Engineers Comments Regarding Surface Water Drainage

Application Reference:	WA/51/26/RES	Reviewer Reference:	ADC/EXT5/AF
Planning Officer:	Simon Davis	Date of Review:	27/07/2026
Site Name:	Land East of Wandleys Lane Fontwell		
Application Description:	Approval of reserved matters following the grant of outline planning permission WA/35/23/OUT, for the construction of 95 No. new homes, access, new pedestrian and cycle links, open space, landscaping, habitat creation, drainage features and associated groundworks and infrastructure, including details relating to the Sensitive Lighting Strategy, POS details and Part M Compliance. This application is in CIL Zone 3 and is CIL Liable as new dwellings.		
Assessment Number:	1

0404 - A03

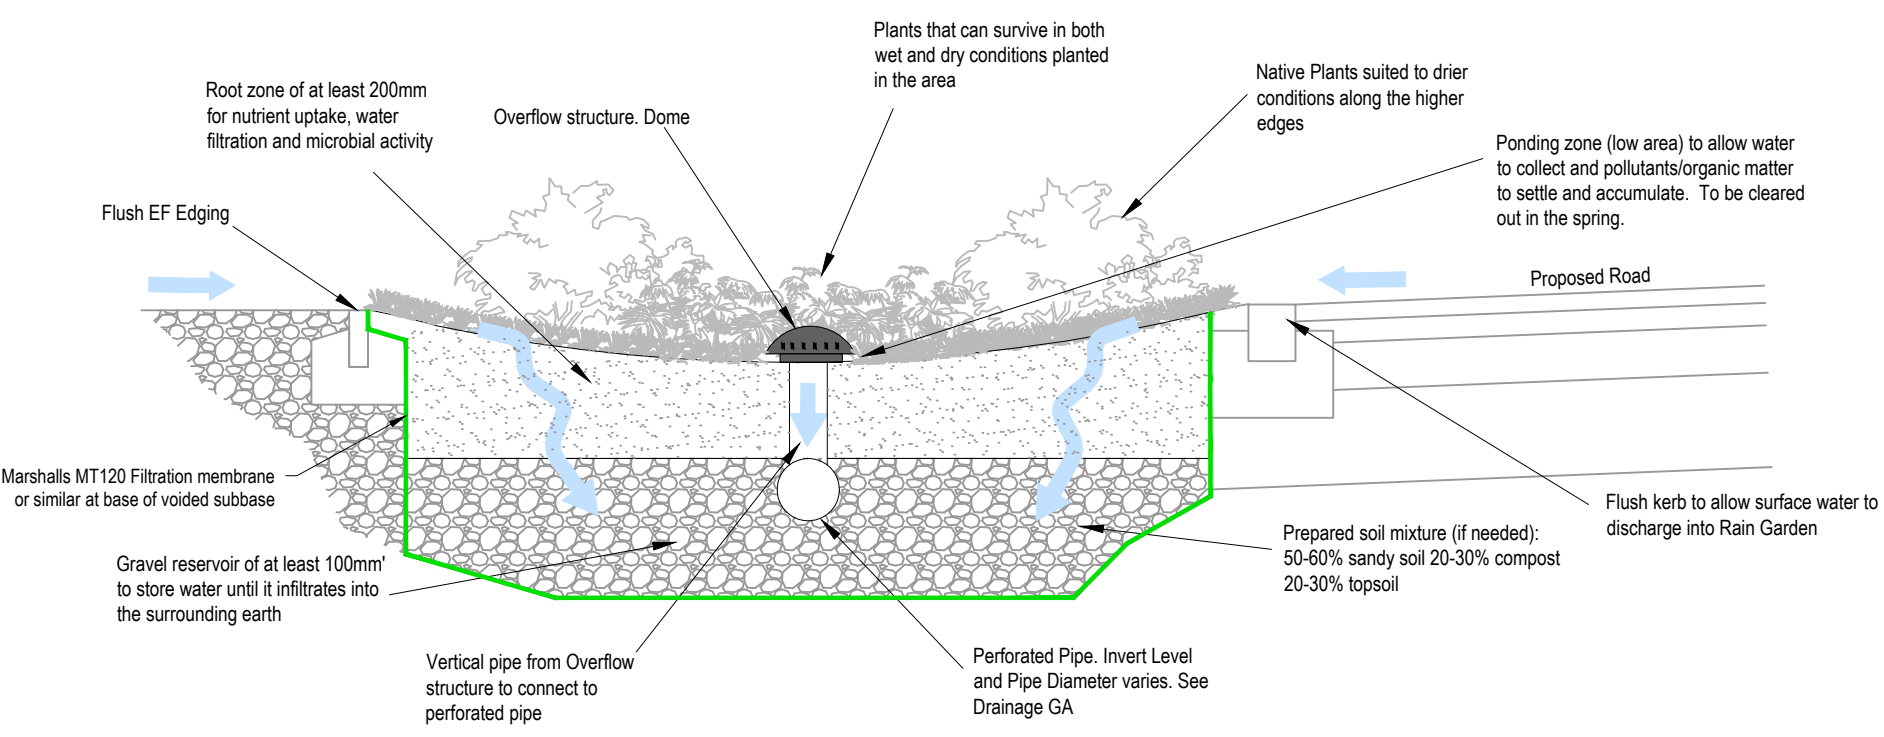
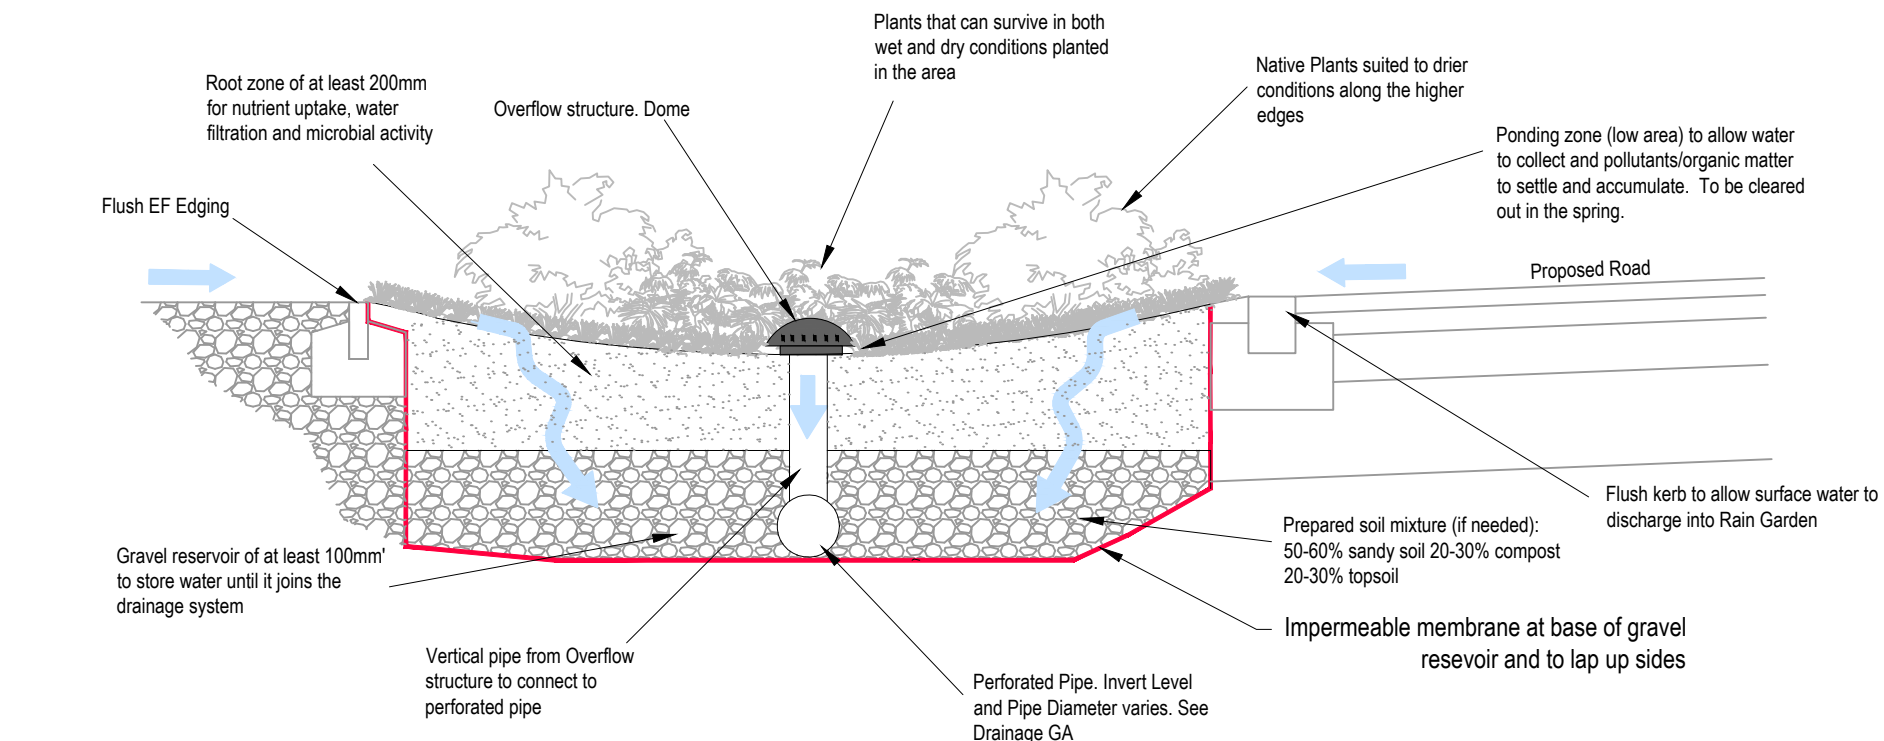
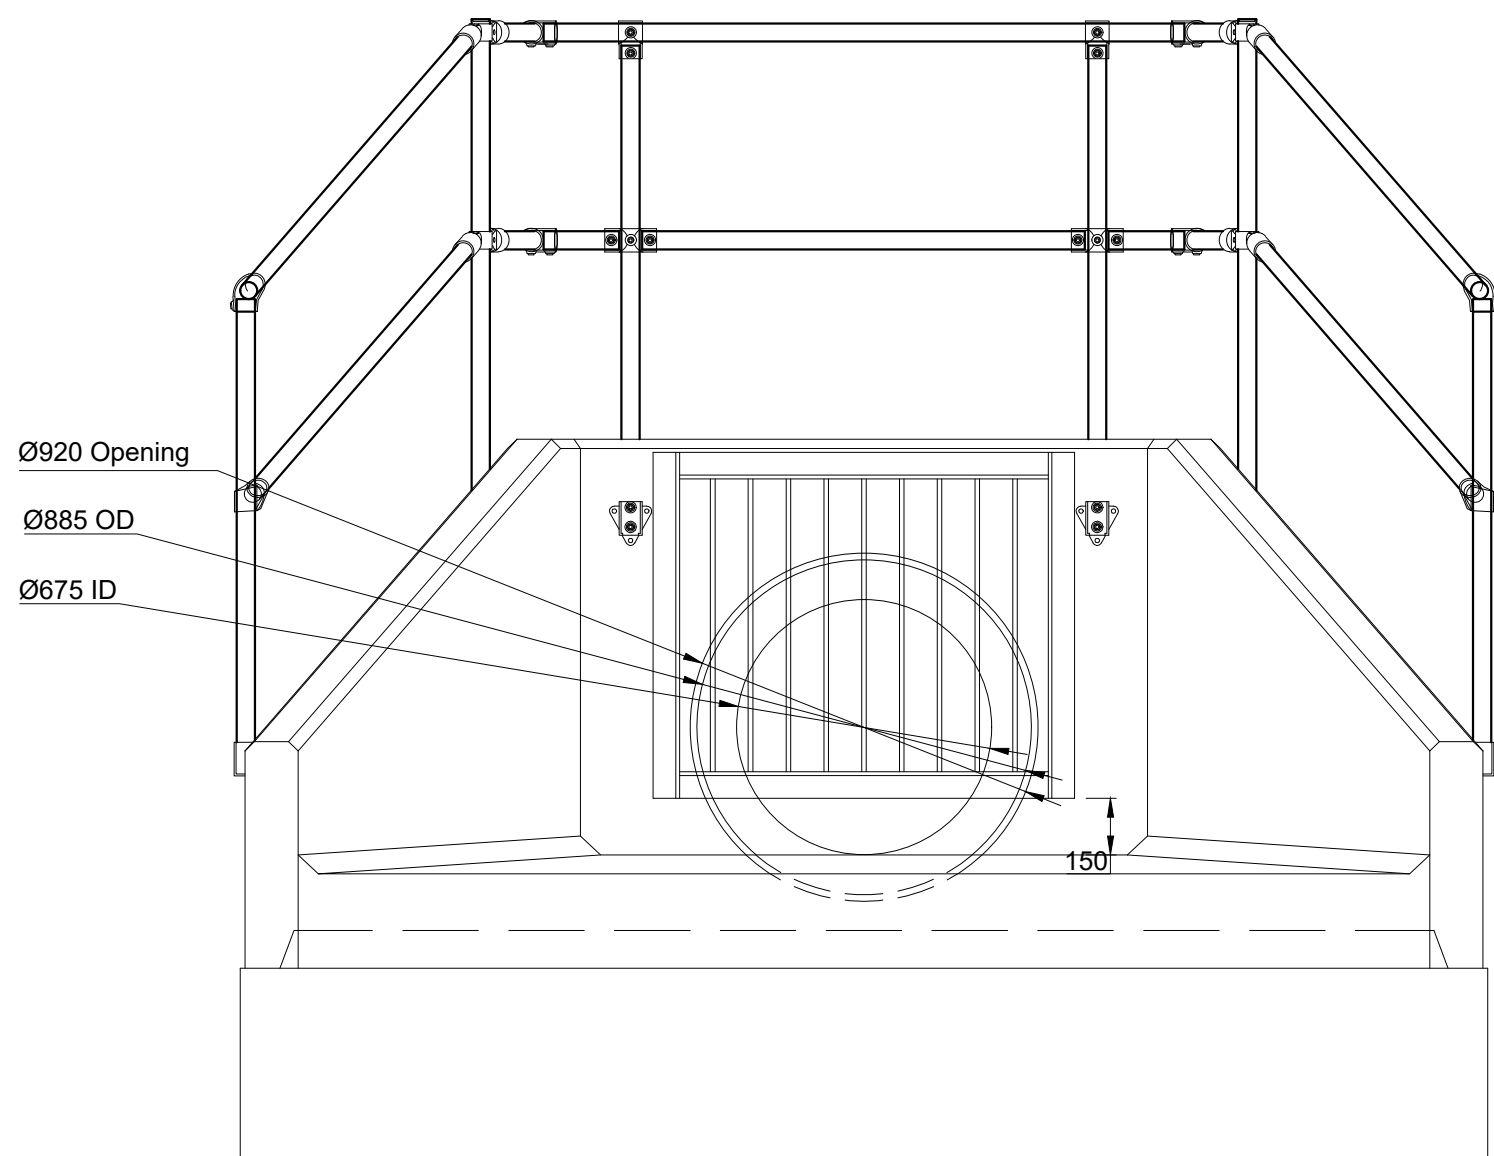
- 1.2. The ground investigation shows relatively shallow groundwater (up to 1.4m bgl) and the subsoil classification may not be suitable for a full infiltration solution. However, there is no infiltration testing present and this is a requirement of Condition 13. There may be potential for a partial infiltration solution or an infiltration solution for a part of the site. A more thorough assessment of infiltration potential and groundwater depths should be included in the current submission.
We have produced a plan showing groundwater depths and infiltration results at each recorded location. Following this review, we can confirm that;
Very localised areas of the site are suitable for infiltration where sufficient freeboard of 1m is available beneath the base of the infiltration feature. In these areas, infiltration to ground has been incorporated through shallow, unlined permeable paving and unlined rain gardens, as shown on the updated drainage plans provided with this submission. To mitigate the risk of inundation, blinding or siltation of the infiltration features, positively connected high-level overflows will be provided to the wider drainage network should infiltration become limited or restricted. Any infiltration benefit from these features has therefore been excluded from the storage calculations, as it is considered that, during extreme rainfall events, these areas could still potentially contribute runoff to the overall

drainage network / SuDS system. These updates can be seen on drawings 5988-005-5551 Drainage Strategy Sheet 1 of 2 A04 and 5988-005-5552 Drainage Strategy Sheet 2 of 2 A04. The updated details can be found on drawing 5988-005-0404 Proposed Drainage Details Sheet 4 of 6 A03
